From: Nicola Spencer on behalf of Planning
Sent: 20 October 2017 17:59
To: Planning Scanning
Subject: FW: 9 Downview Avenue
Attachments: Prop Elevations.pdf

Please could you upload as Planning correspondence freetext: comments from agent on FG/129/17/HH

Subject: 9 Downview Avenue

PROPOSED ELEVATIONS

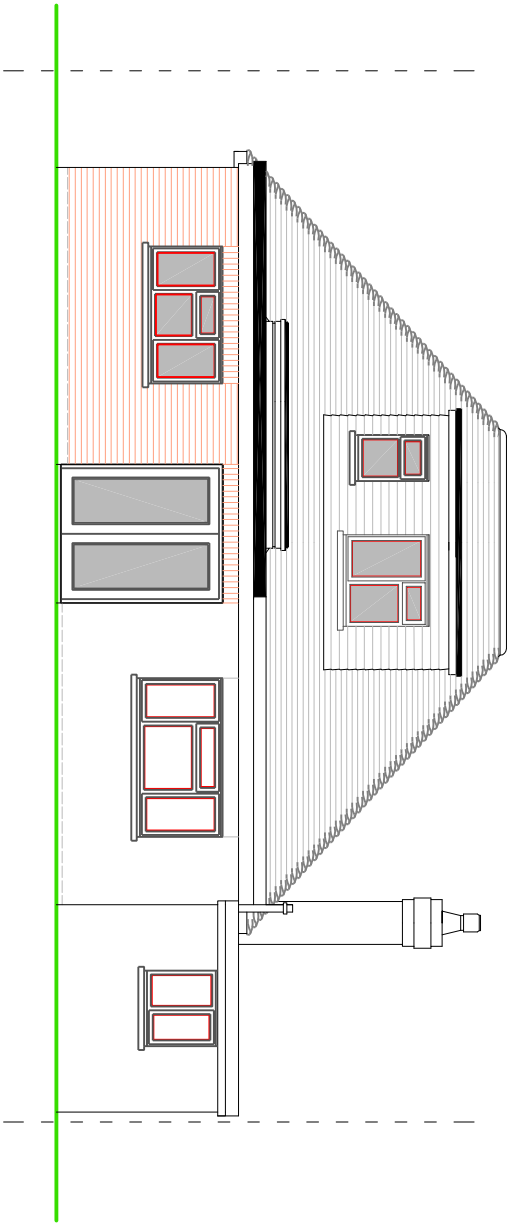
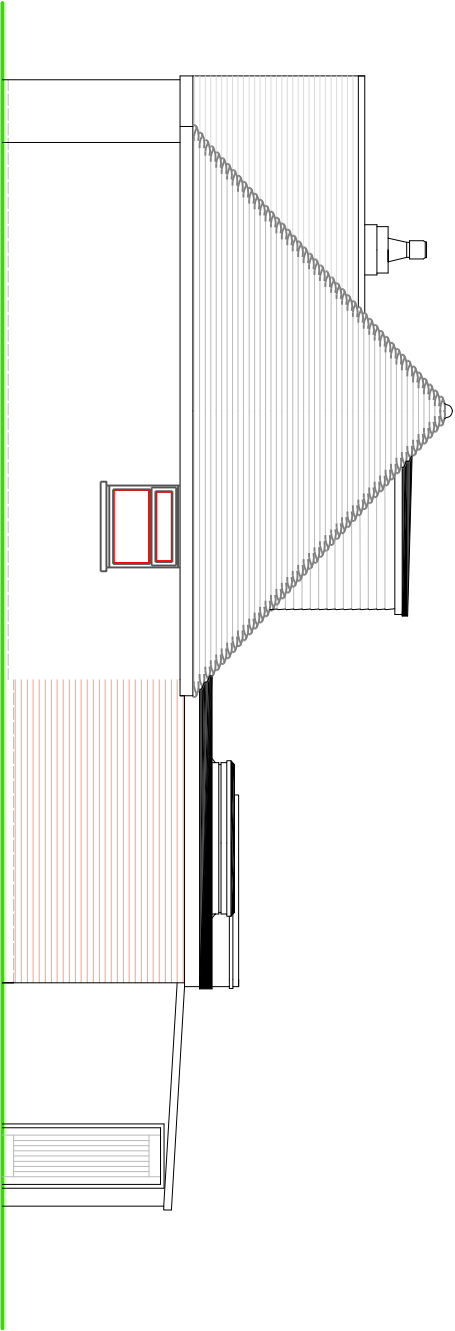
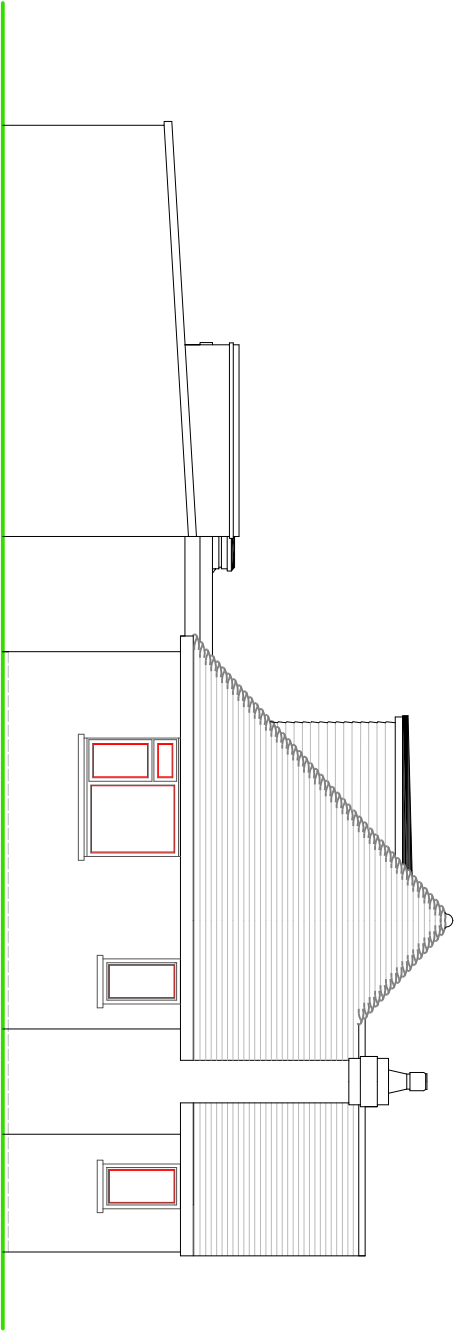
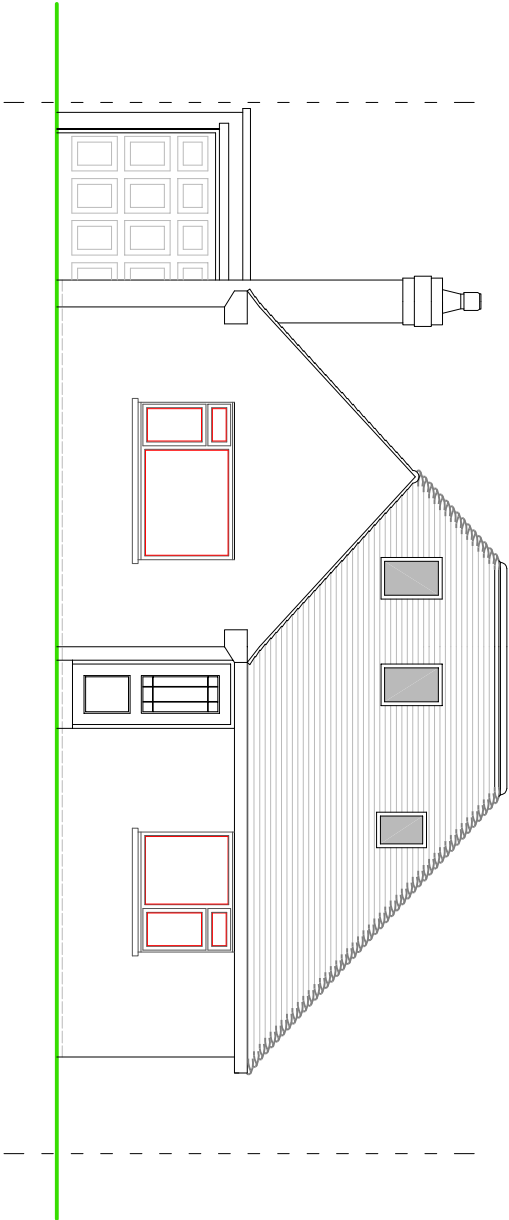
I am in process of preparing report on the above. I have one query can you confirm the material for the dormer window extension i.e. is it clad and if so the type or tile hang.

Sorry, should have said – tile hanging to match existing.
